Our Ref: BE/5/20/PL

14th January 2020

Town & Country Planning Act 1990 (as amended)
Town and Country Planning (Development Management Procedure) (England) Order 2015
Application for Planning Permission

Development New Kelvion gas cooler to replace existing unit (like for like replacement)
Location Sainsburys Supermarket Ltd Shripney Road Bognor Regis

Drawing Title:
Location Plan
Drawing Status:
Planning

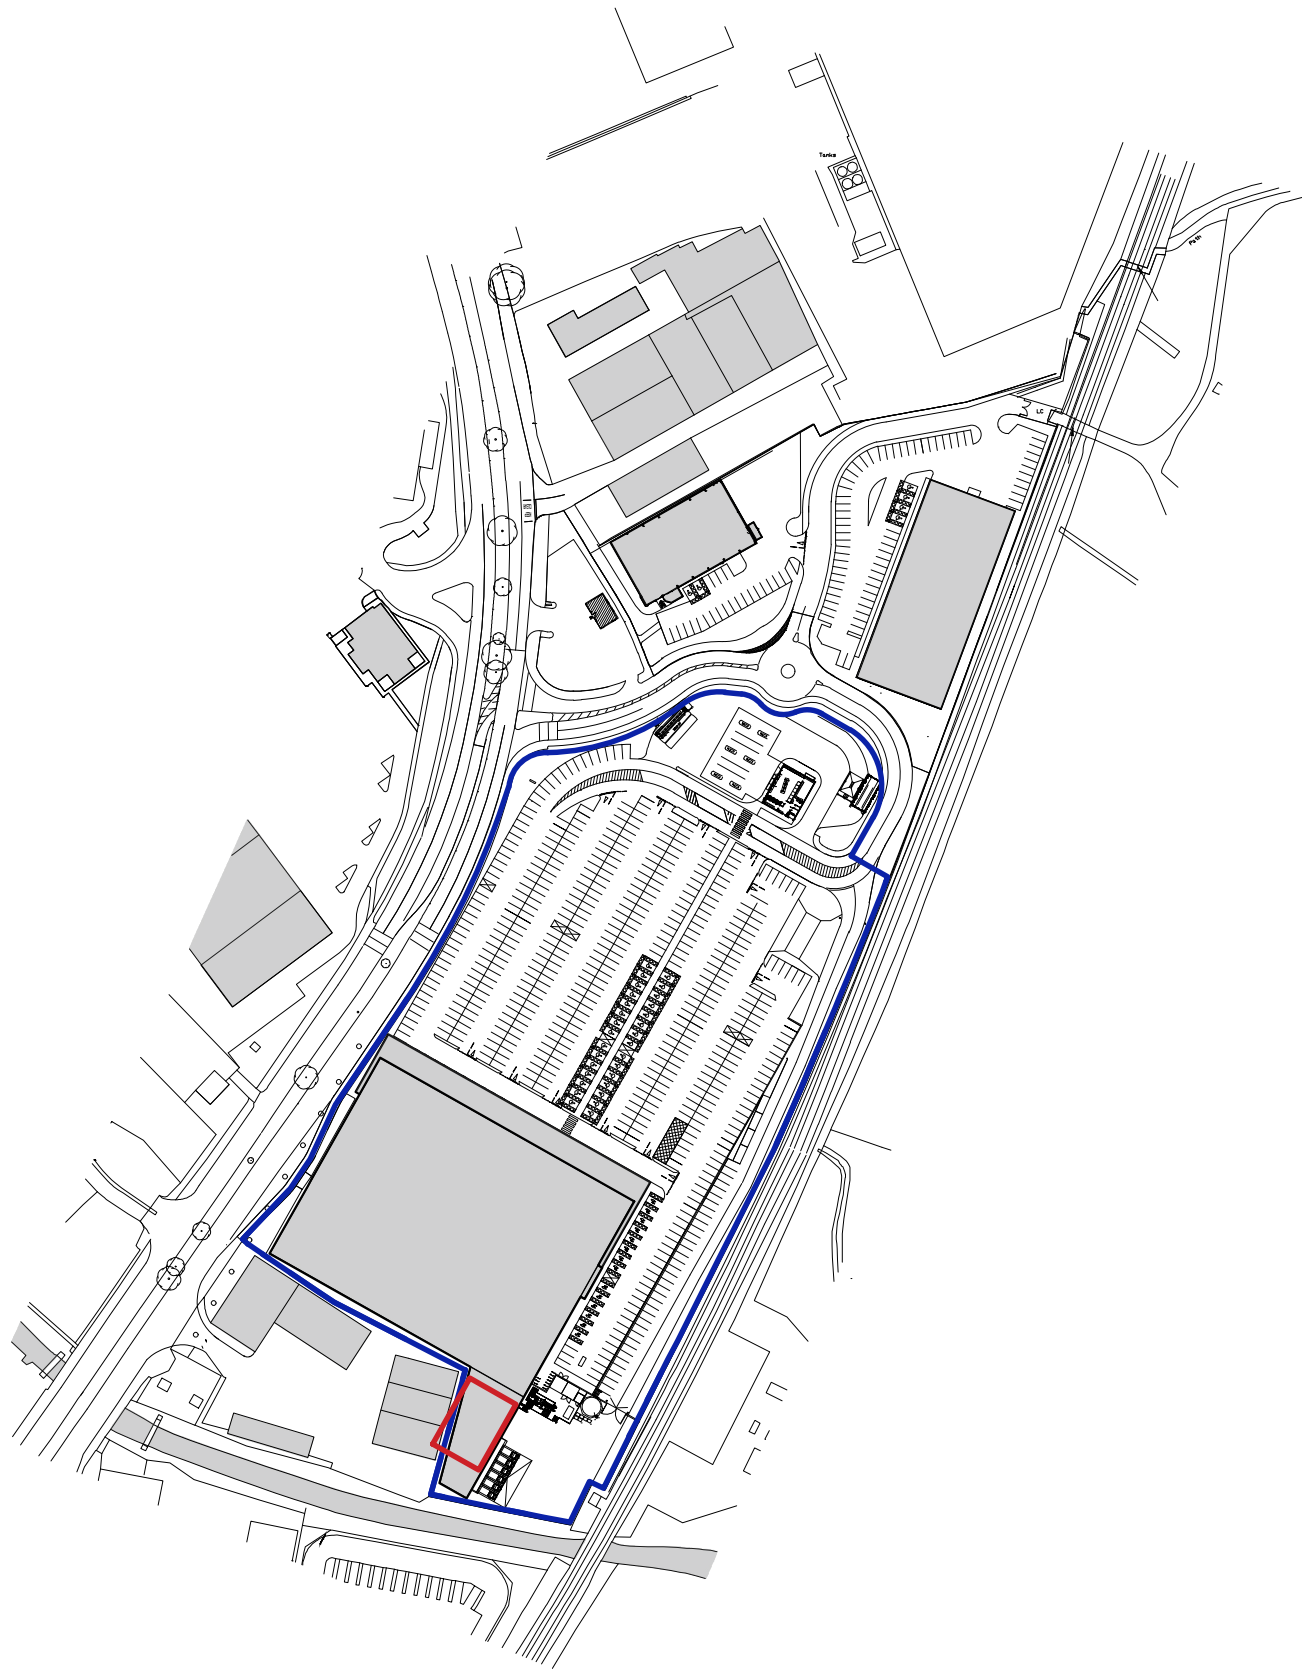
Question 4 - I believe that this figure is incorrect. It should be the site area contained within the red edge. From measuring your plan, I think this should be in the region of 494sqm. Please confirm.
